Your ref: SSD-45576956
Our ref: DOC25/364522

**Subject: Environmental Impact Statement – Children’s Medical Research Institute (CMRI)
Gene Technologies Building (SSD-45576956)**

CPHR advice on EIS – CMRI Gene Technologies Building (SSD-45576956)

Figure 4 - Flood map provided by Council (based on Upper Parramatta River Catchment Floodplain Risk Management Study and Plan, Bewsher, 2003)

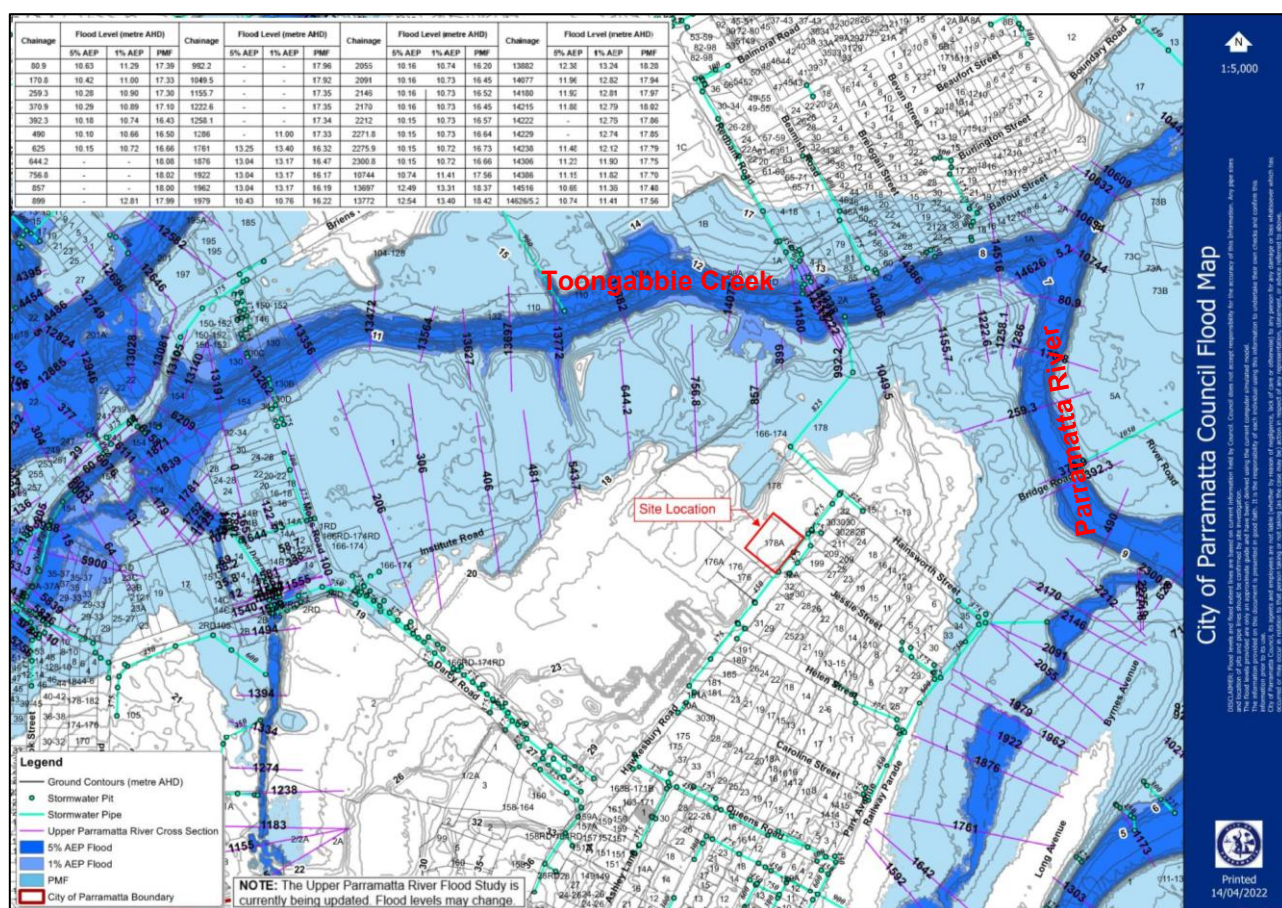
1.	<i>Flood modelling must align with the current Council flood study</i>	The Flood Report (page 7) states, 'A Flood Enquiry application was submitted in April 2022' and includes information from the now superseded Upper Parramatta River Flood Study. This information is outdated as Council adopted the PRFS in June 2024. The Flood Report does not include the PRFS in the list of guidance documents under Section 1.4. The flood mapping in the PRFS shows substantially more inundation on the subject site from what is shown in the Flood Report. The PRFS also shows no flooding on Hawkesbury Road at the subject site because an appropriate depth filter has been applied to the flood model results before mapping. CPHR recommends that the proponent contacts Council to access flood model data from the PRFS. The proponent must verify their models against the PRFS for the full range of flooding events, and include the following: 1. The PRFS was calibrated following a flood frequency analysis for the Marsden Street Weir. The initial flow estimates based on Australian Rainfall and Runoff (2019) methodology and were factored up by around 30%. Council can provide guidance on the relevant approach to calibrate flows for this SSD. The factoring methods are varied by watercourse and/or overland flow. The proponent must calibrate their flood model so that the flows match Council's model. 2. Following calibration, the Flood Report must present relevant hydrographs for at least the 1% Annual Exceedance Probability (AEP) and Probable Maximum Flood (PMF) events. These modelled hydrographs must demonstrate similarity in shape and peak flow, and a similar water volume to Council's model. 3. All relevant structures such as drainage infrastructure must be compared between the two models. The proponent may require clarification from Council to resolve any discrepancies or adopt the data directly from Council's model.
